30th November 2020

Application No: EP/125/20/PL
Site Address: 128 Sea Road East Preston BN16 1NN
Description of works: Alteration & extensions to flat to create 2 No. one-bedroom self contained flats including loft conversion and dormers (as approved EP/41/19/PL). This site is in CIL Zone 4 & is not CIL Liable as new flat.

Elevations (1:100)

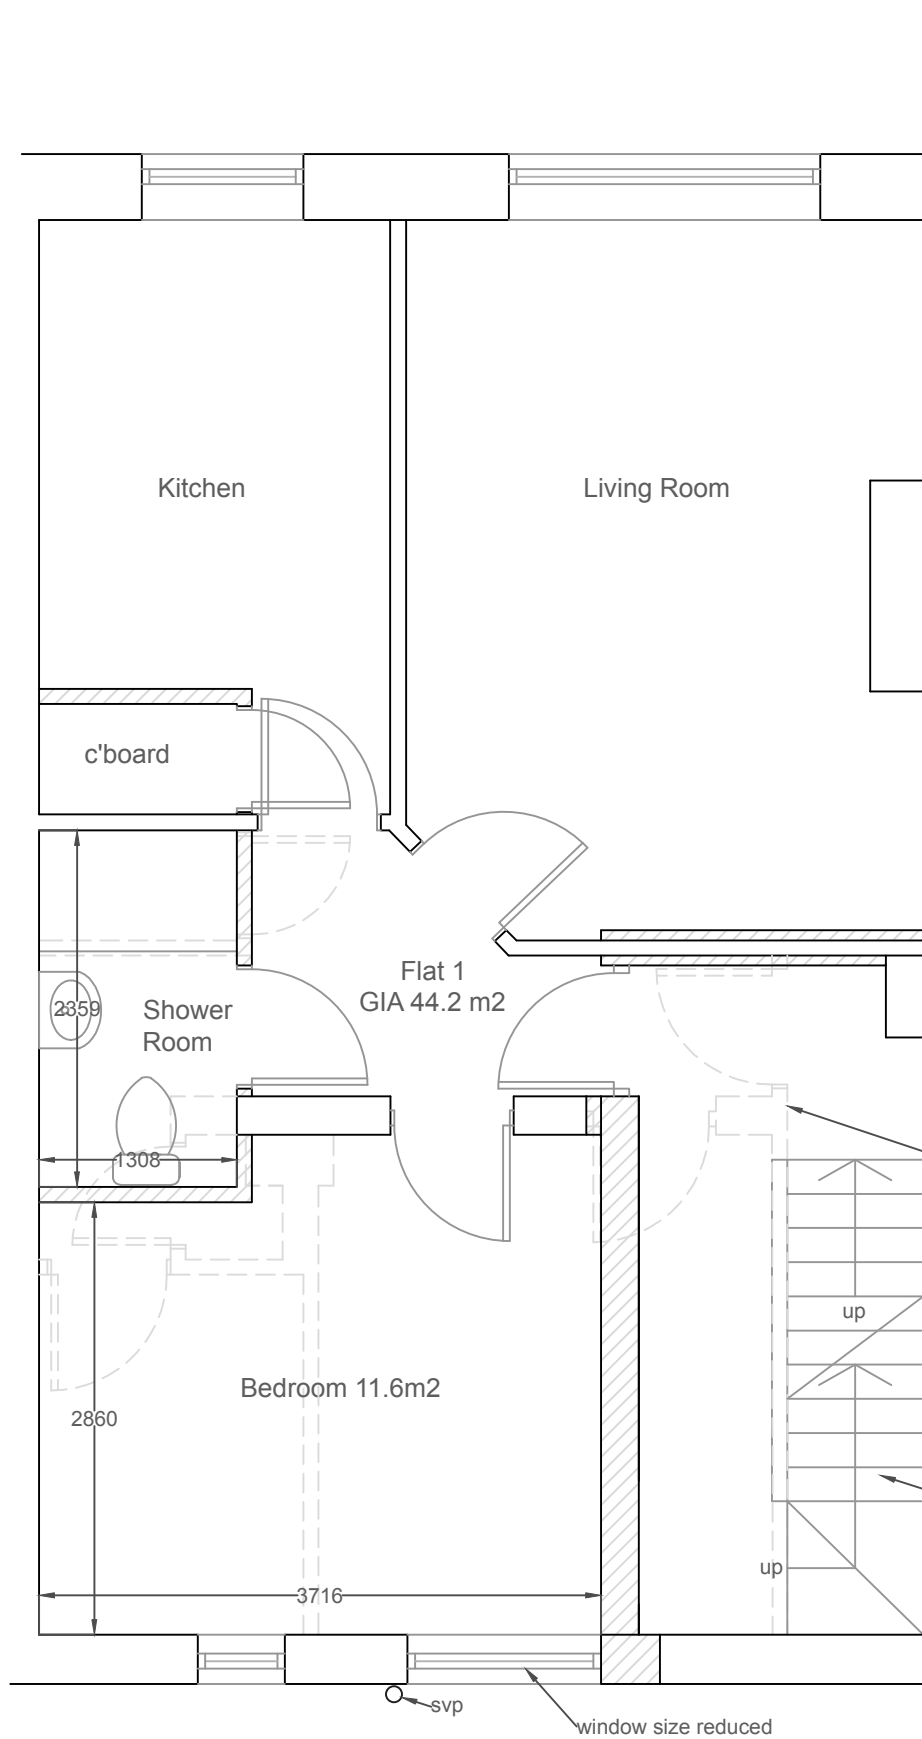
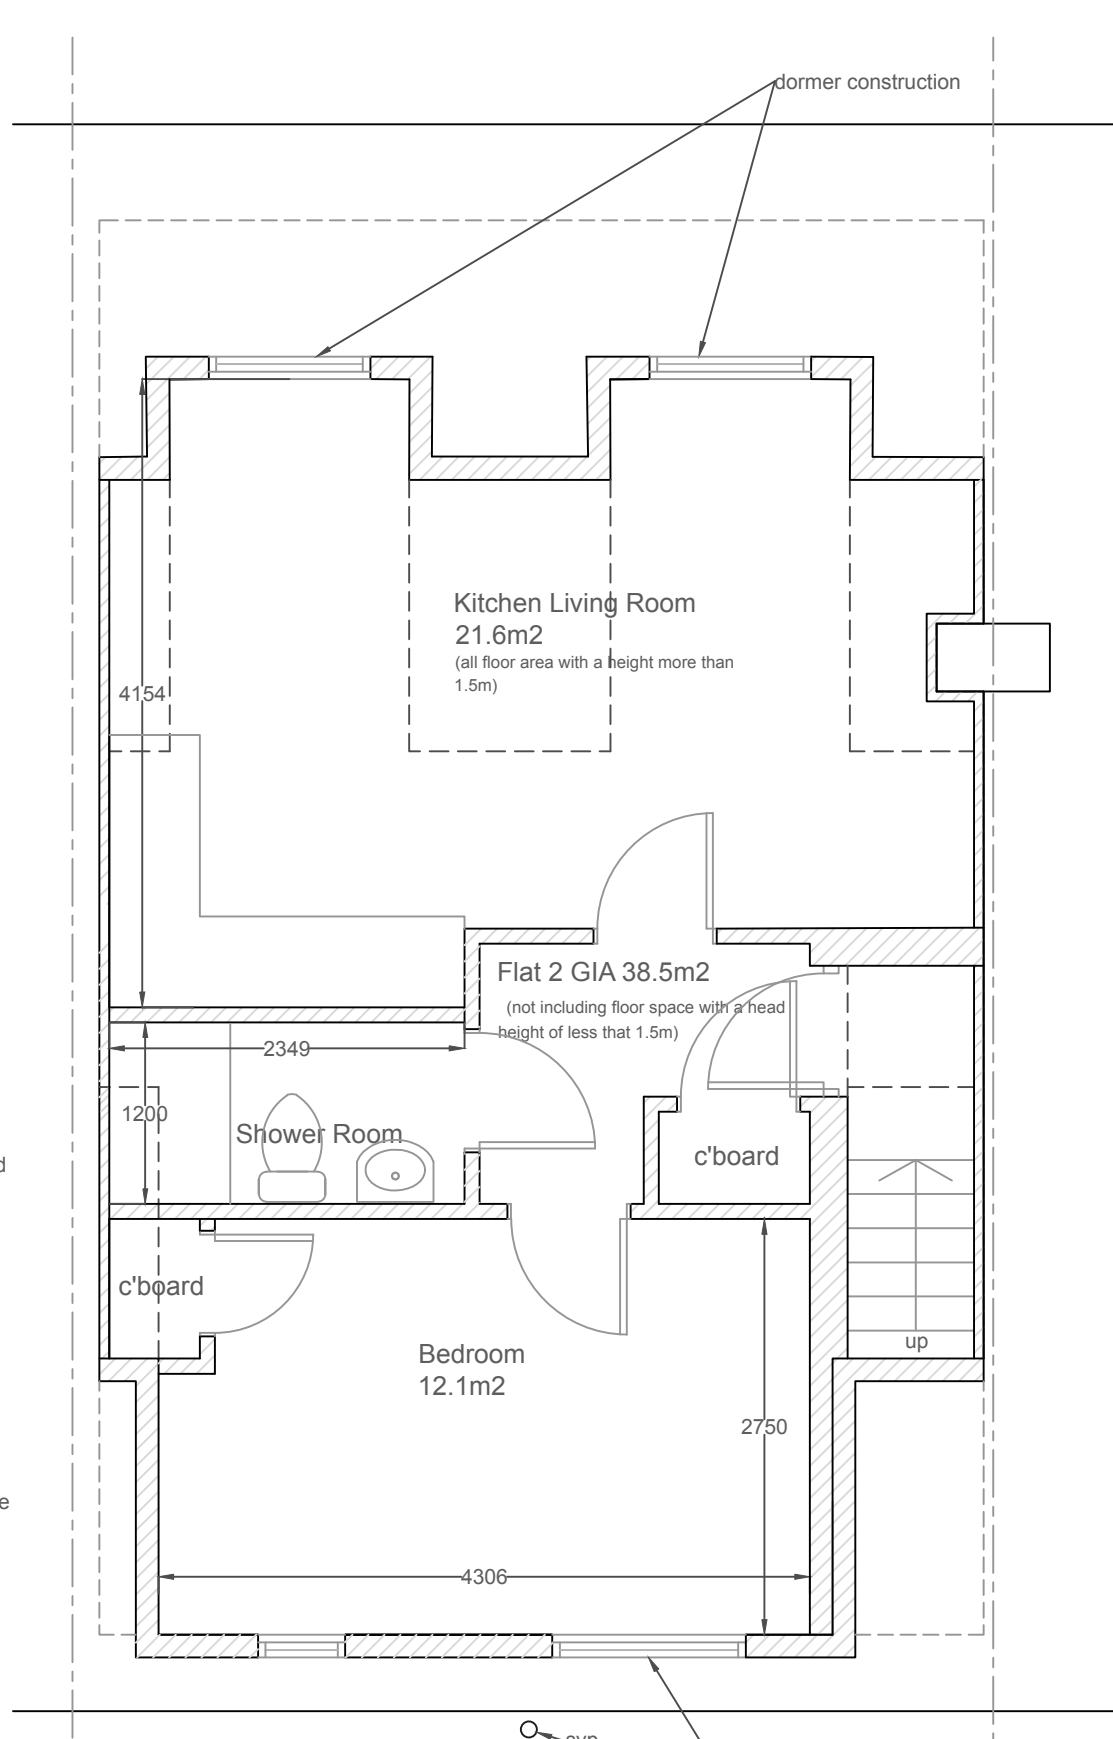
The committee agreed it had no objections to raise against this Application, although there was still some concern the front dormer would not be in keeping with the rest of this parade of shops.
